**Our ref:** RA/2023/145899/01-L01  
**Your ref:** 2023/91441

**Date:** 13 June 2023

**CHANGE OF USE AND ALTERATIONS TO FORMER CHURCH (B8-STORAGE) TO 9 RESIDENTIAL UNITS (C3) AND FORMATION OF CAR PARK (LISTED BUILDING WITHIN A CONSERVATION AREA) – 31 CHAPEL HILL, LINTHWAITE, HUDDERSFIELD, HD7 5NJ**

**Environment Agency position**

Drawing:  
 Proposed  
 Site Sections

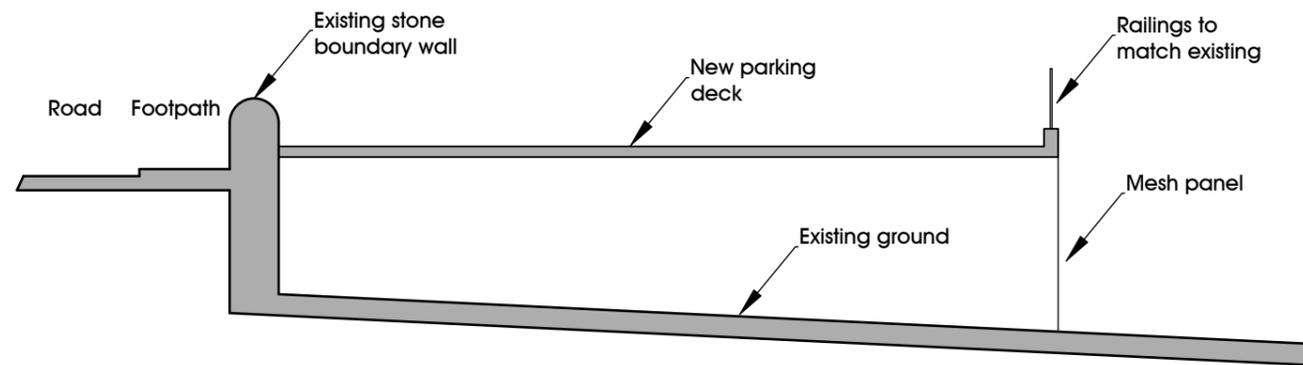
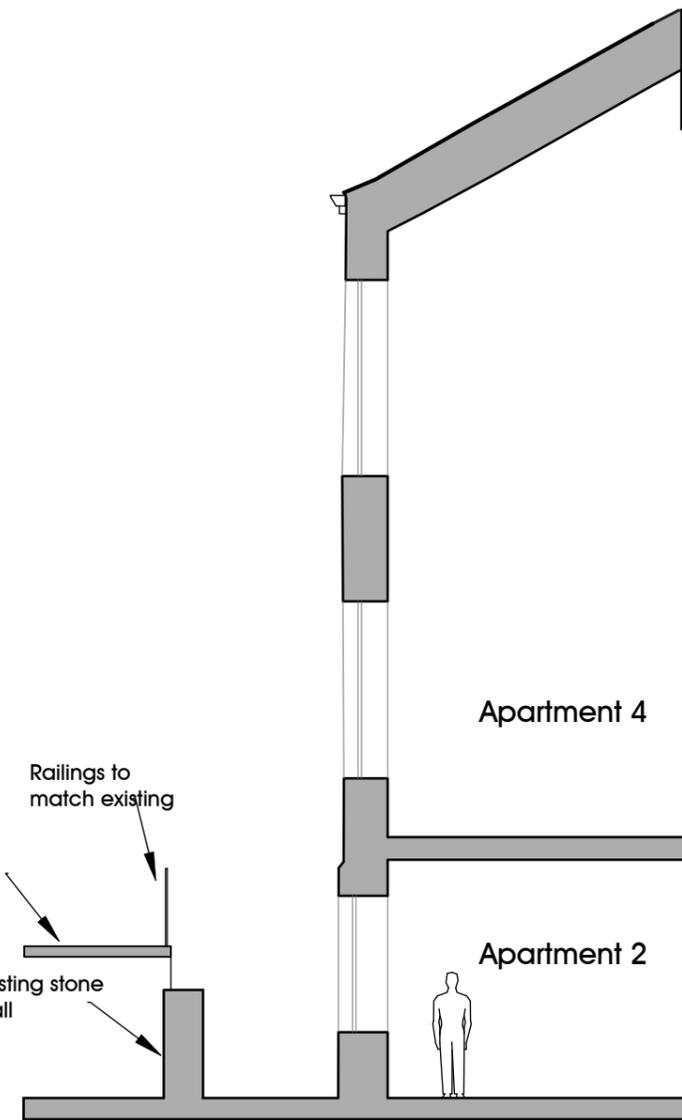
- It is ambiguous where the proposed development falls in relation to the culvert that runs through the site. Please provide a scale site map that shows the location of the culvert in relation to the works.
- If the car park is built over the culvert, we would object to this proposal as such works may reduce the ability to maintain the culvert in future, compromise the structure of the culvert, or preclude future options for de-culverting (or opening up) the watercourse in this location in future. We advise that an 8m (or greater) easement from the culvert edge is incorporated into the design to reduce any impact on the structural stability of the culvert. If the work is within 8m of the culvert a structural stability assessment and flood risk assessment should be submitted to assess the impacts of the work upon the culvert and surrounding area.
